Our Ref: EV54

6 August 2010

**RE: CULTURAL HERITAGE ASSESSMENT OF LOT 490 KINGSCLIFF
RESPONSE TO AGENCY SUBMISSIONS DATED 23 MAY 2010**

AGENCY SUBMISSIONS – LOT 490 KINGSCLIFF

ABORIGINAL PROTECTION ZONE AS IDENTIFIED IN CULTURAL HERITAGE ASSESSMENT

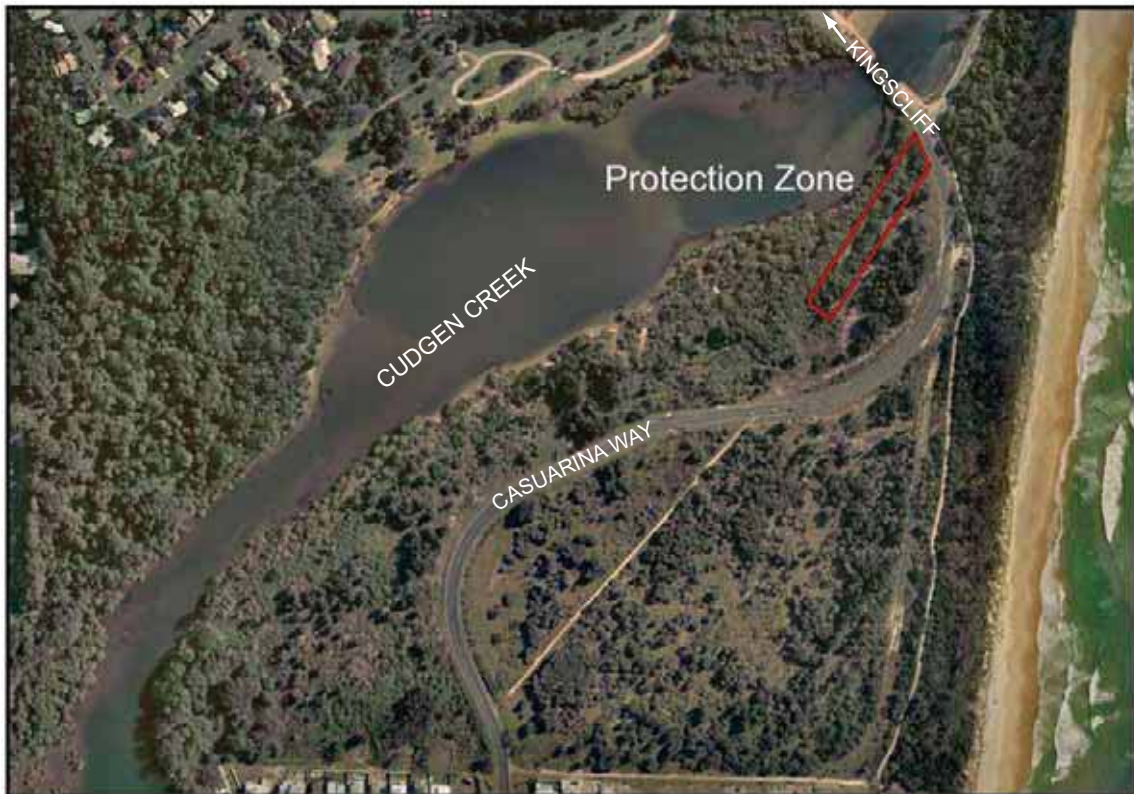
<p>Protection Zone:</p> <p>1. Evidence of support from Stakeholders is required.</p>	<p>The minutes for the site meeting document the support of the Stakeholders for the proposed Protection Zone. At no stage has any Stakeholder expressed concerns about this proposal. Everick will seek further evidence of the Stakeholders opinions on the Protection Zone.</p>

<p>2. Long term management plan recommended.</p> <p>3. Proponent should provide further details to confirm the mechanism which will be used to ensure</p>	<p>The long term management principles of the CHPZ should be incorporated into the RMP for the Project.</p> <p>Everick understand that the Protection Zone is within lands owned by the New South Wales Land and Property Management Authority, not the Proponent. The Proponent has a lease over the eastern portion of Lot 490 with an obligation to maintain the surrounding Lot 490 Plan of Management area (within which the Protection Zone is located). This maintenance obligation will be met through the production and implementation of the RMP. The RMP therefore provides an effective, enduring mechanism for ensuring the CHPZ is managed appropriately into the future. Everick has provided the Proponent with the appropriate management protocols, in accordance with the <i>National Parks and Wildlife Amendment Act 2010</i> (NSW).</p>
